From: Carol Reynolds
Sent: 08 June 2018 14:05
To: Planning.Responses
Cc: Michael Eastham
Subject: FW: Planning Consultation on: A/40/18/OUT

Environmental Health:

1. Acoustic Environment

Noise in habitable Rooms: I refer to The Noise Assessment prepared by Phlorum Ltd in respect of the above development, dated February 2018. The report describes acceptable glazing requirements, together with proposed means of ventilation for properties facing the A27 and Water Lane which would otherwise fail to provide a suitable internal acoustic environment within noise sensitive habitable rooms, as defined by The World Health Organisation (WHO) and BS8233:1999. The preferred method of alternative ventilation will be acoustically treated mechanical ventilation.

Figure 2: Baseline Noise Measurements

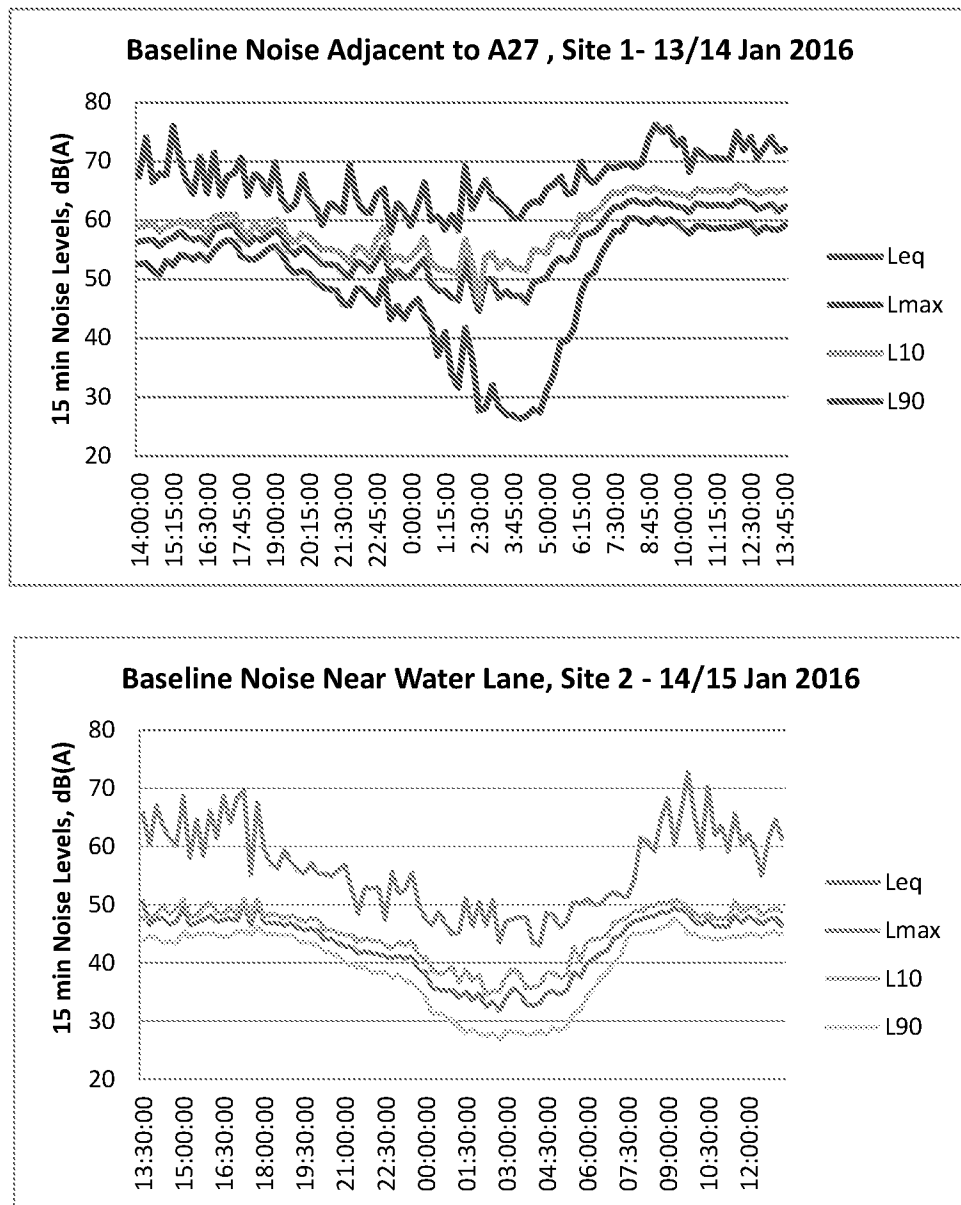
However, having visited this site, then in my opinion this report should also include the measured effect of the nearby and noisy A280 and the effect of multiple existing light industrial units, farm businesses and cattery in Dappers Lane in order to better describe the level of noise and acoustic attenuation that may be required to properties to the east and west of the site. This is particularly necessary given that businesses may no longer be required to carry out works to reduce noise output where a sensitive receptor moves to an existing use. This will also better inform any acoustic attenuation necessary in the case of offices/other employment opportunities which may be provided to the southern boundary; notwithstanding investigation that will be necessary here in respect of the proposed new roundabout at the junction of Water Lane and the A280. Measurements in respect of the A280 should reflect the previous noise monitoring strategy as above, whereas those in respect of the western flank should closely reflect the hours of operation of these units.

It shall also be necessary to demonstrate at each perimeter, north, south and east of the development, the number of times during the night time period 23:00 to 07:00 hours when the level of noise met or exceeded the guideline level of 45dB LAMax. Proper means of acoustic mitigation to be detailed as necessary.

It is anticipated that further noise monitoring to the east of the site and in respect of the A280 will better inform any requirements for acoustic attenuation to the amenity spaces of residential units here and similarly in the case of houses adjacent to existing light industry /farm businesses in Dappers Lane.
